TECHNICAL MEMORANDUM

Project No. 07-1121-0037

**GRADING PLAN REVIEW - REVISED
BLOCK 14 – 25 OVERBERG WAY
BRIDLEWOOD TRAILS SUBDIVISION – PHASE 2
OTTAWA, ONTARIO**

GRADING PLAN – 114013-GR

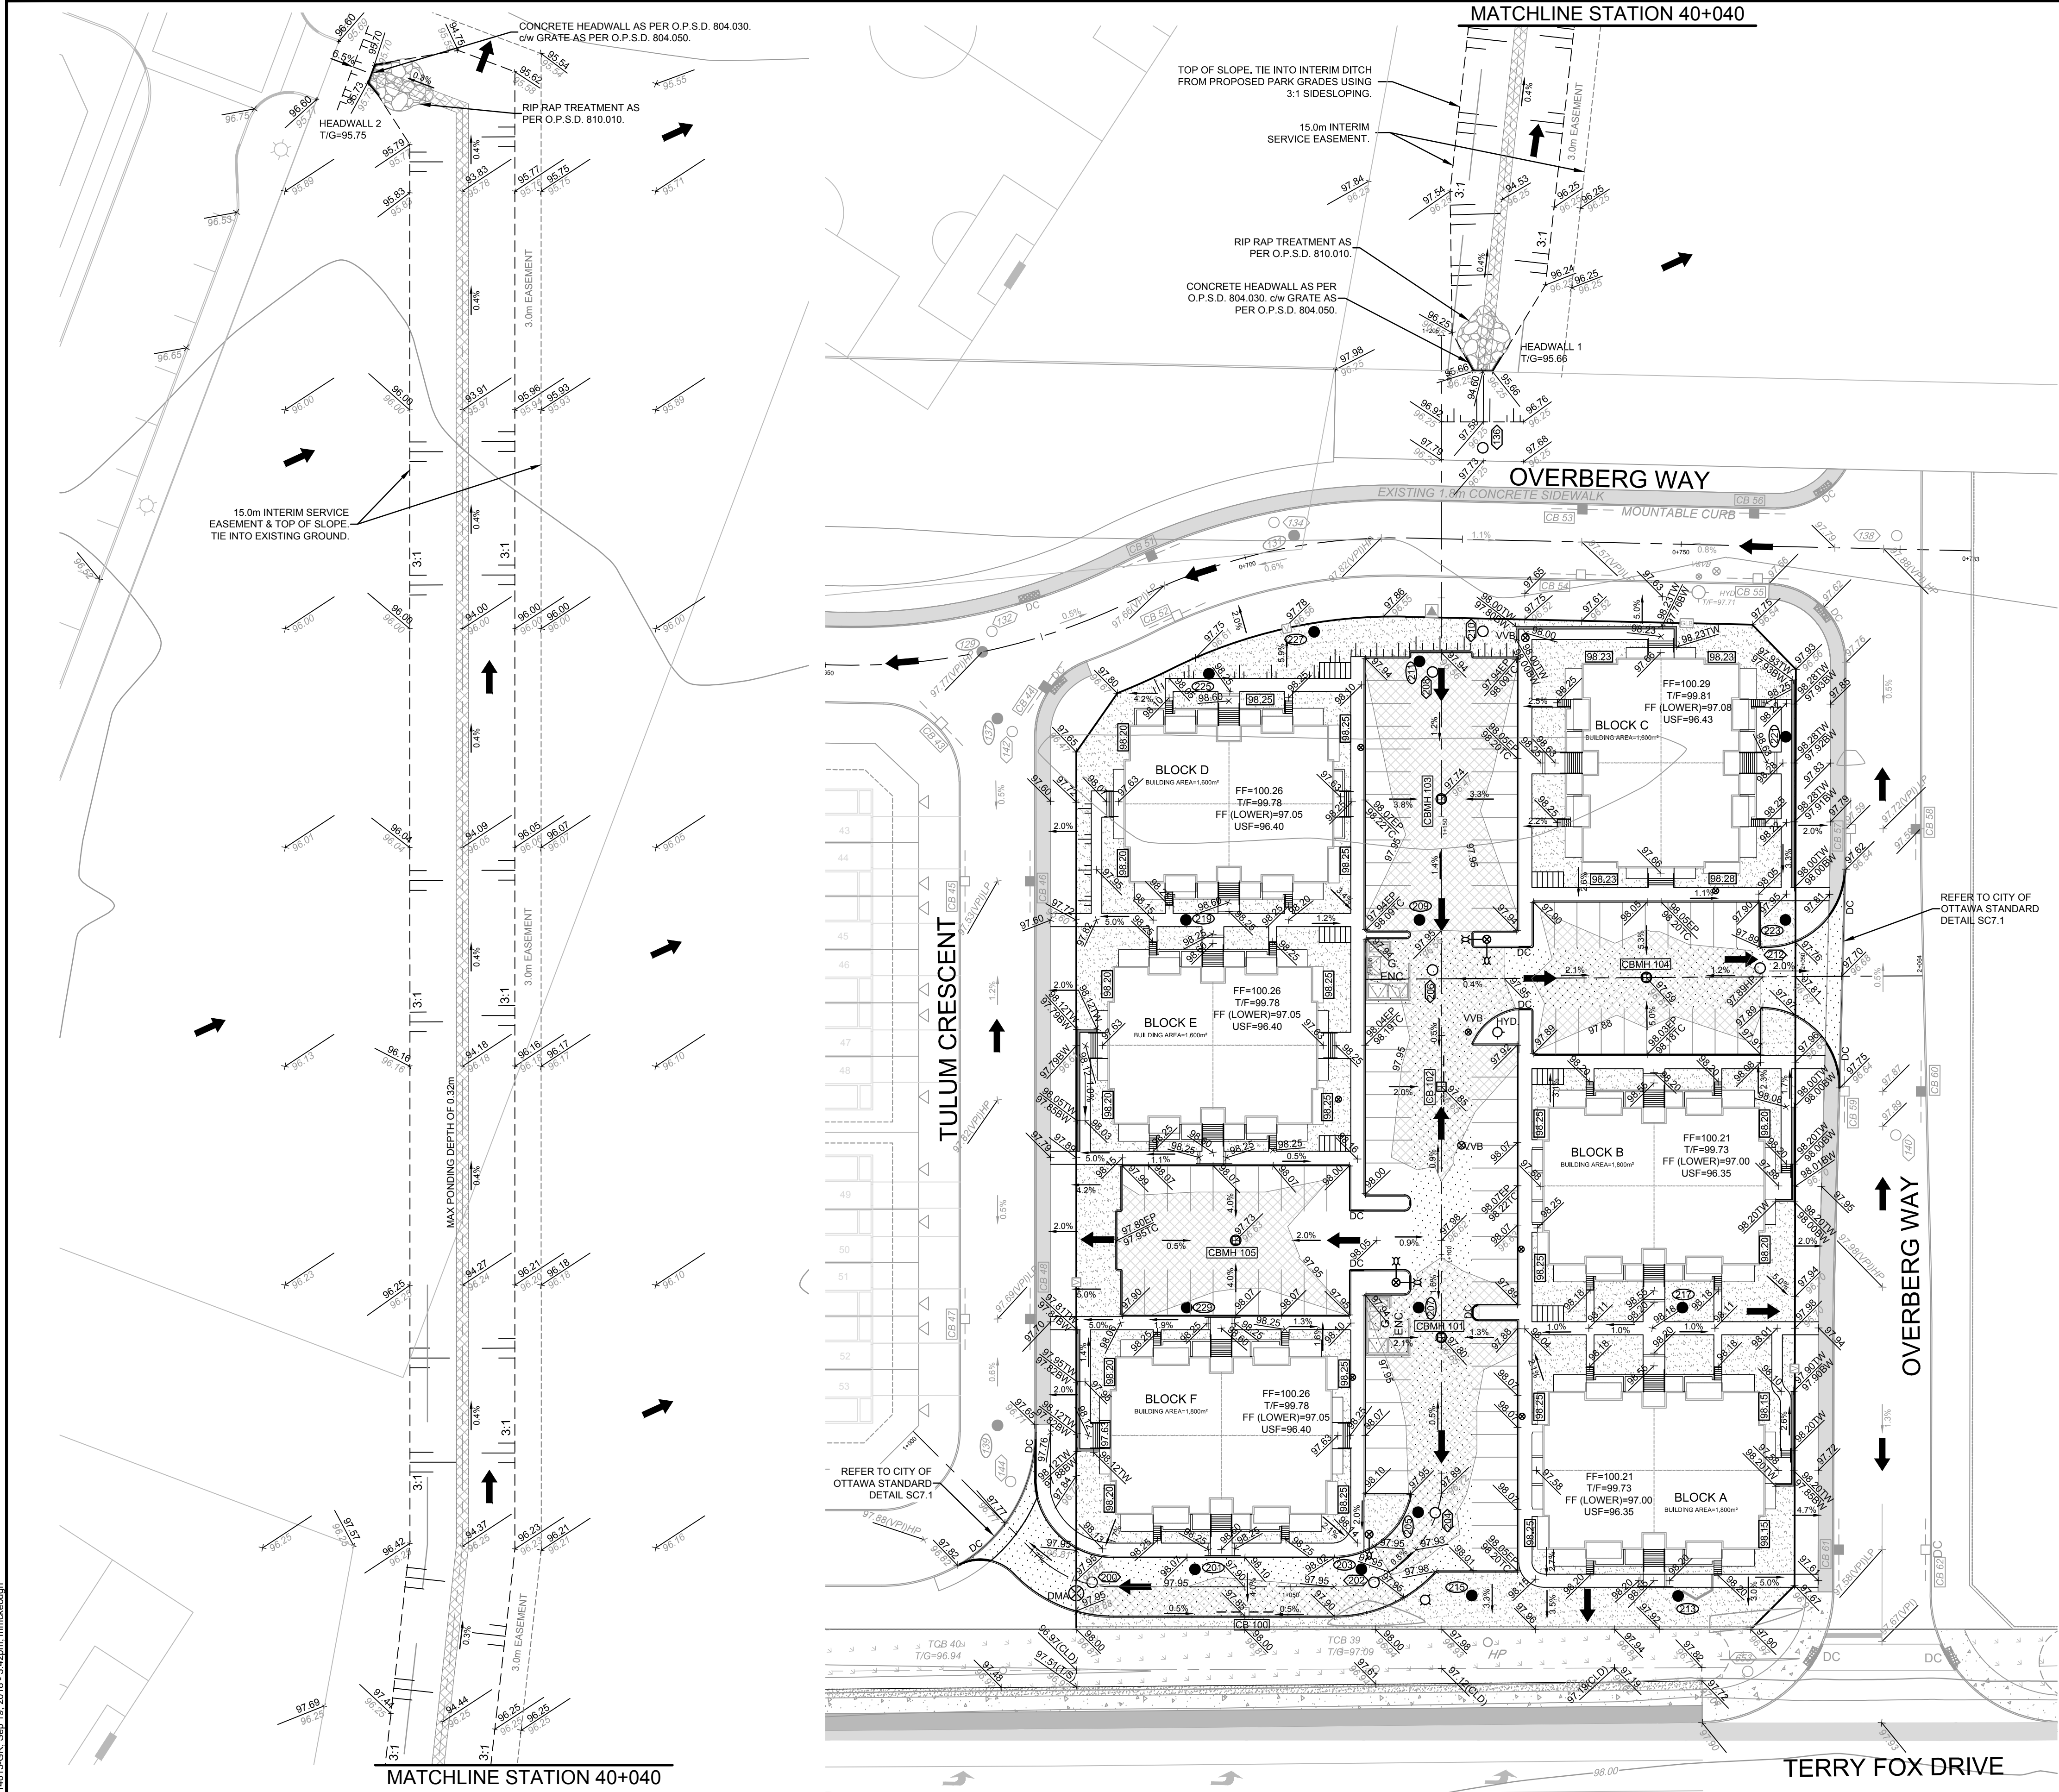
The existing and finished grades and underside of footing elevations for the above lots are provided on the Grading Plan Drawing Number 114013-GR, Revision 12, dated January 18, 2019, prepared by Novatech Engineering Consultants Ltd. – Project No. 114013.

Based on the above grading plan and a review of the specific geotechnical data for this part of the site, the grade raise for these blocks exceeds the allowable grade raise at this site of 0.9 metres. Therefore, expanded polystyrene (EPS) Geofoam light weight fill is required in the porch and above any exterior footing projections. The EPS must extend a minimum of 1.0 metres out from the foundation walls, even if the footings do not. The EPS should extend from the top of the footings to at least the underside of the topsoil at the finished grade level, with a maximum topsoil thickness of 0.3 metres.

All exterior footings or footings in unheated areas should be provided with a minimum of 1.5 metres of earth cover (or equivalent) for frost protection purposes. Isolated, unheated footings adjacent to surfaces which are cleared of snow cover during winter months should be provided with a minimum of 1.8 metres of earth cover (or equivalent).

The finished grades, lightweight fill requirements, and underside of footing elevations were reviewed and are found to be in accordance with the guidelines and recommendations provided in the geotechnical report prepared for this site and, as such, are considered acceptable from a geotechnical point of view.
